From: [Lauren Anderson](#)
To: "[Brad Sturman](#)"
Subject: RE: CAO17-004 ESA Second Review
Date: Monday, August 28, 2017 5:08:00 PM

From: Lauren Anderson
Sent: Monday, August 21, 2017 5:03 PM
To: 'Brad Sturman' <brads@sturmanarchitects.com>
Subject: CAO17-004 ESA Second Review

Please refer to the attached second ESA review letter. CAO17-004 is WCI until the City receives the information requested within the attached letter. We are requesting additional information due to the proposed storm drain and catch basin being within the piped watercourse, we do need

1	DRAINAGE AND GRADING PLAN
2	TESC PLAN

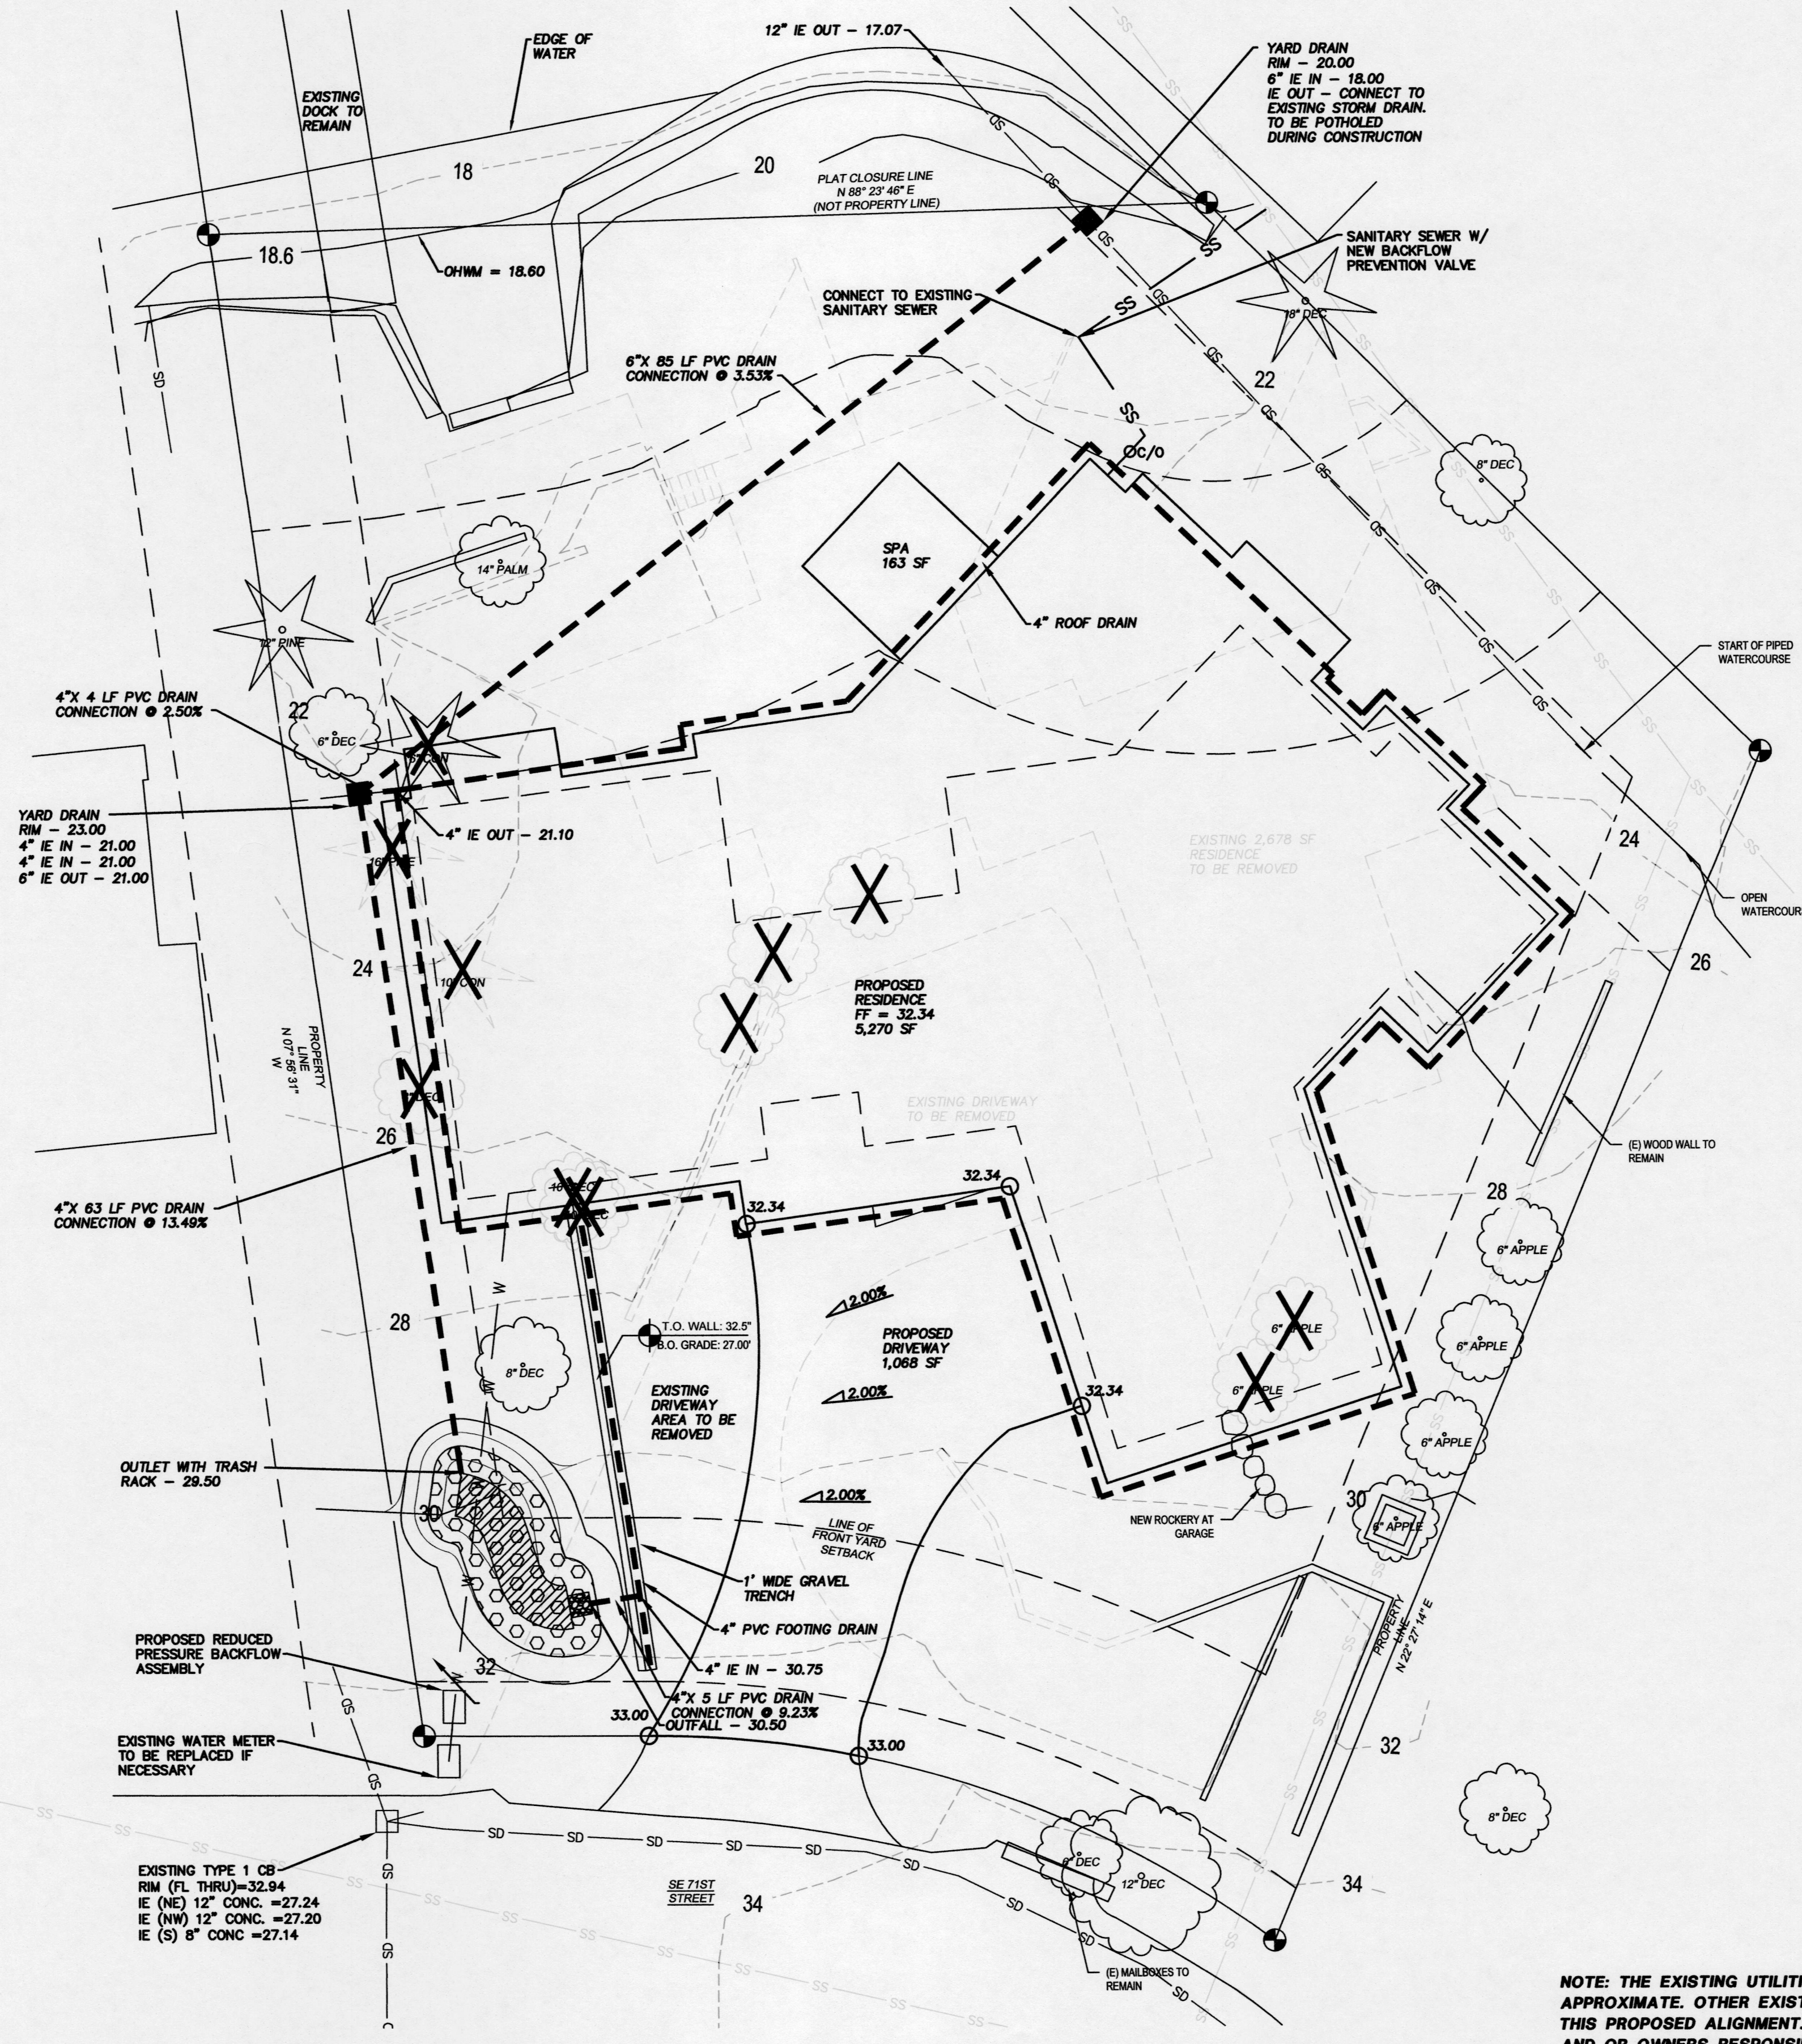
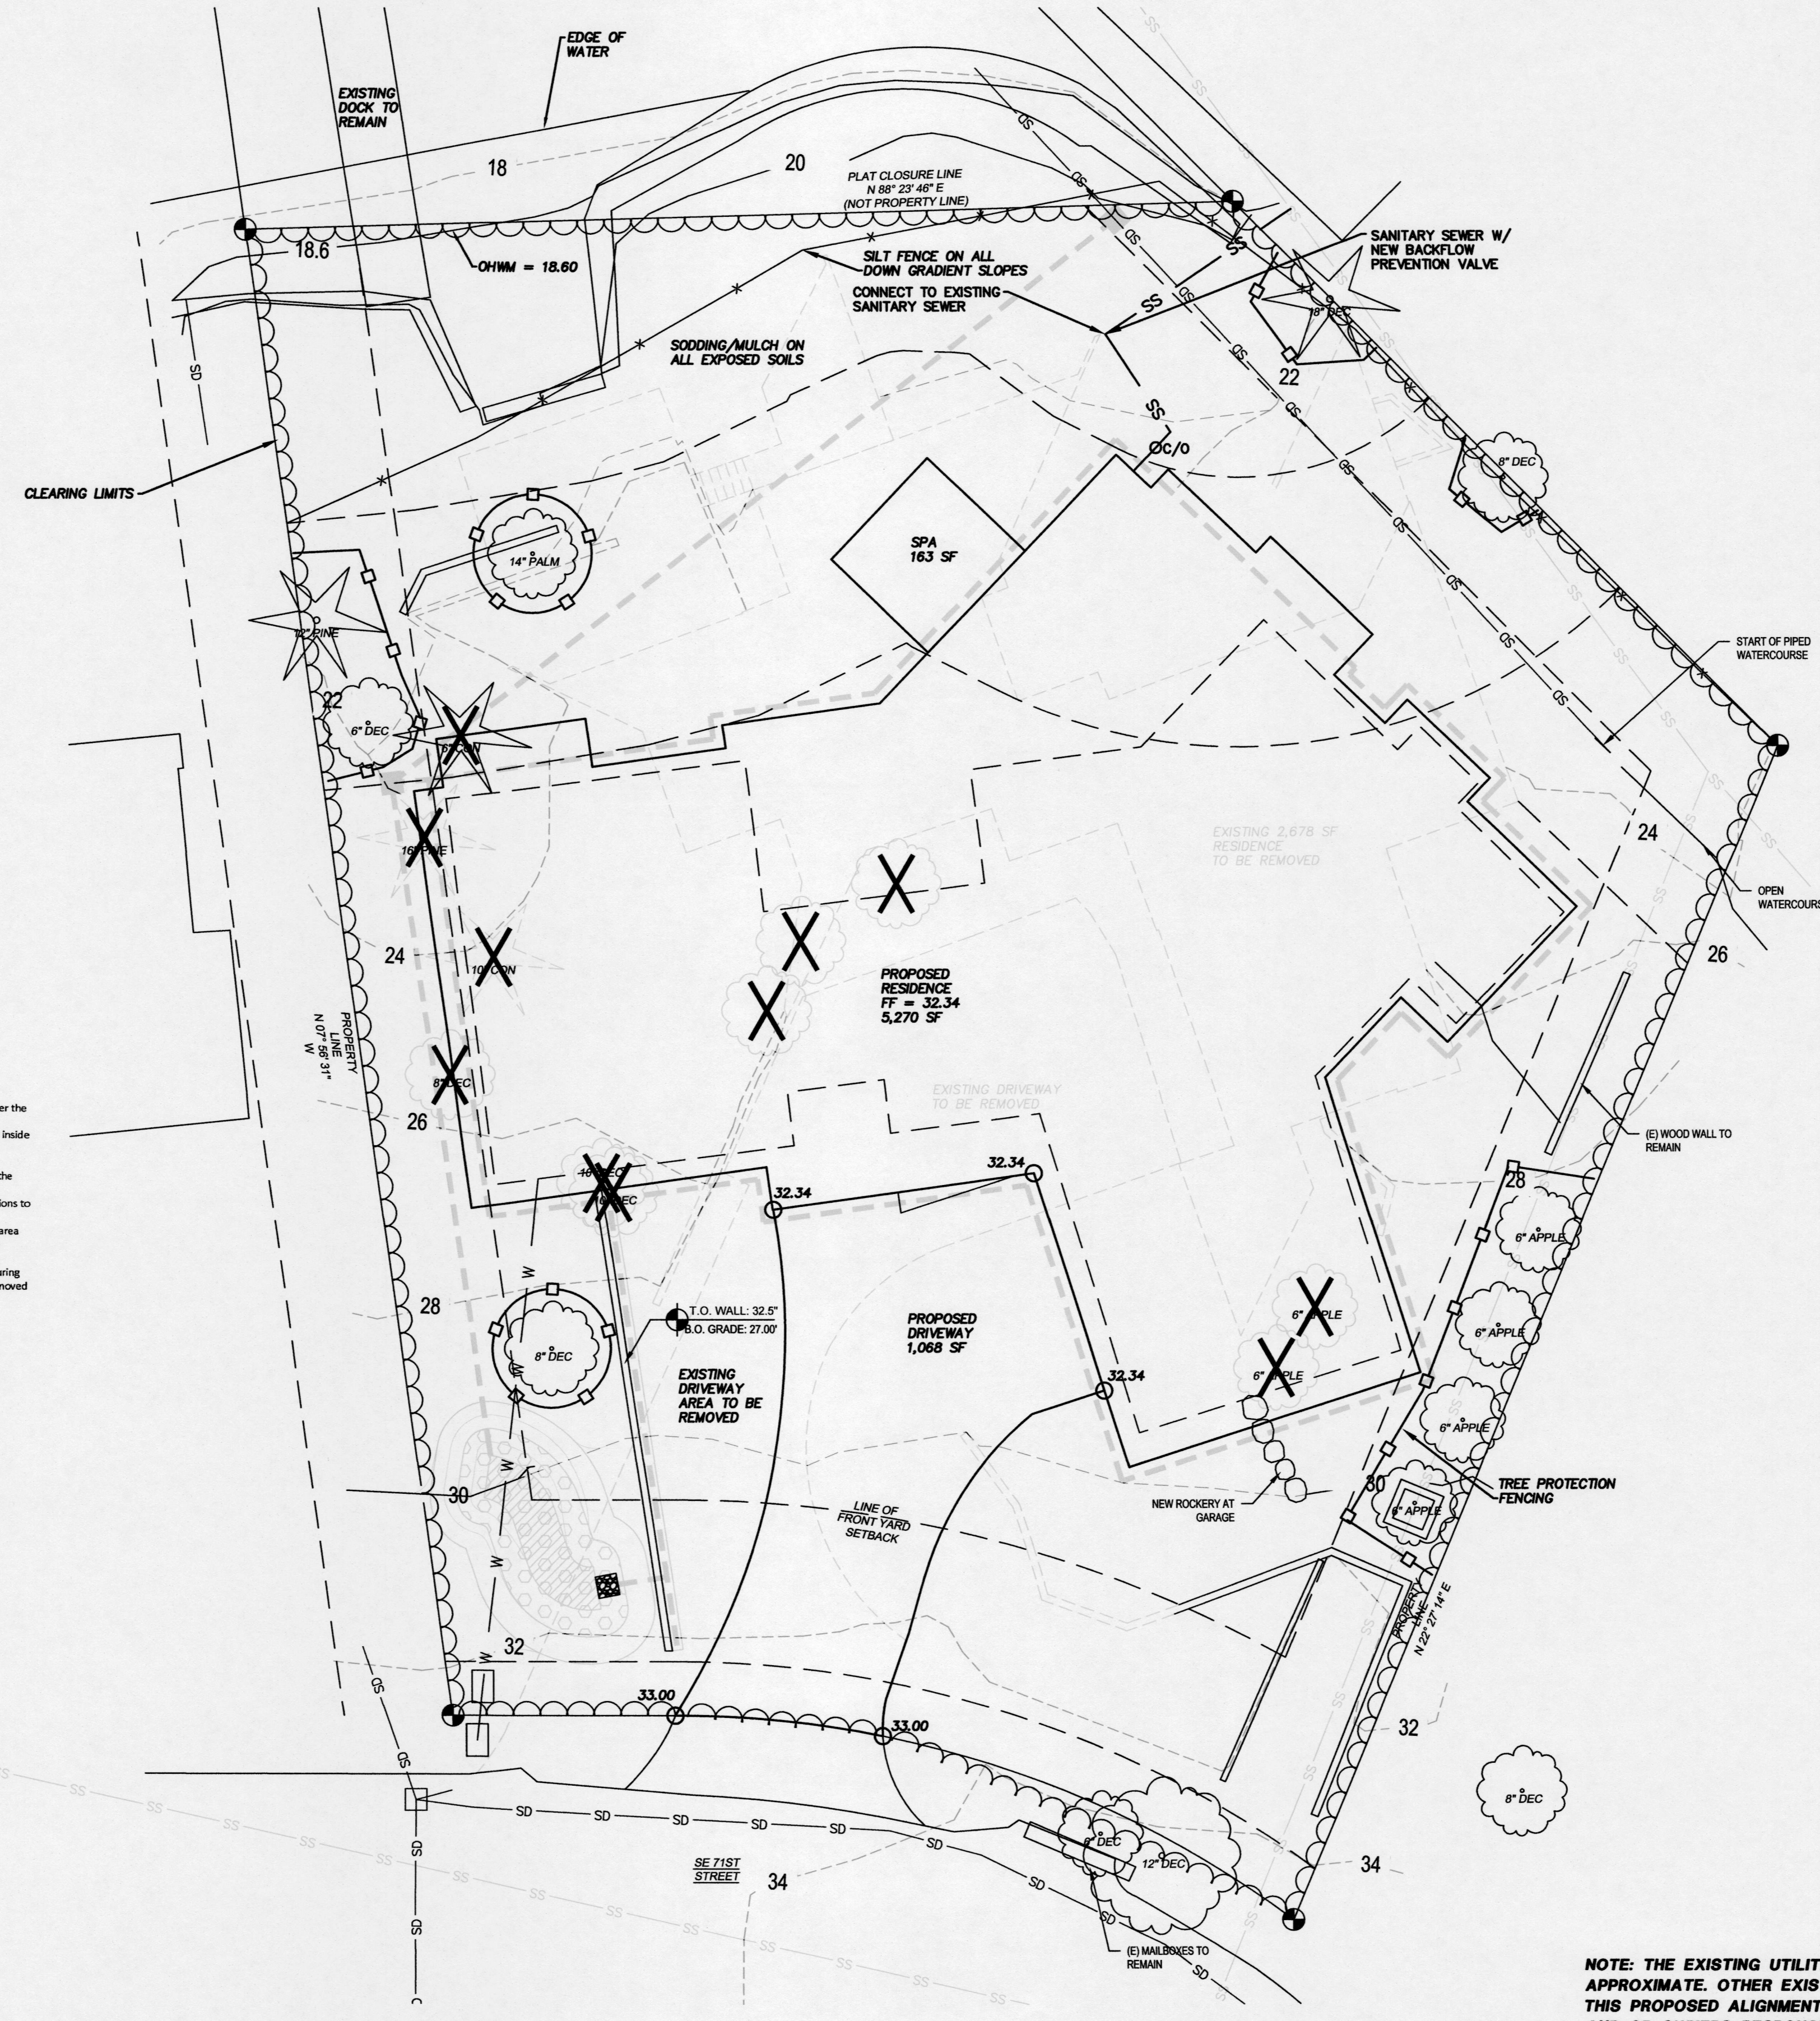
In addition to Aaron Booy's review comments, MICC 19.07.030 (7)(b) best available science focuses first on avoidance and if that's not possible, then mitigation for the impact(s). Please provide in your response your reasoning as to why you chose that location for the storm drains and pipes as the current location impacts both watercourse buffers. Is one 6 inch pipe running under the eaves not feasible, please elaborate. Is locating the storm drain and pipe on the eastern side of the property and connecting to the open and piped watercourse an option? Is it possible to reduce the amount of pipes and intrusion to minimize the impact?

additional information on how the proposal is meeting MICC 19.07.030 (7) New Utilities. Mitigation options include a pervious driveway or a vegetated bioswale.
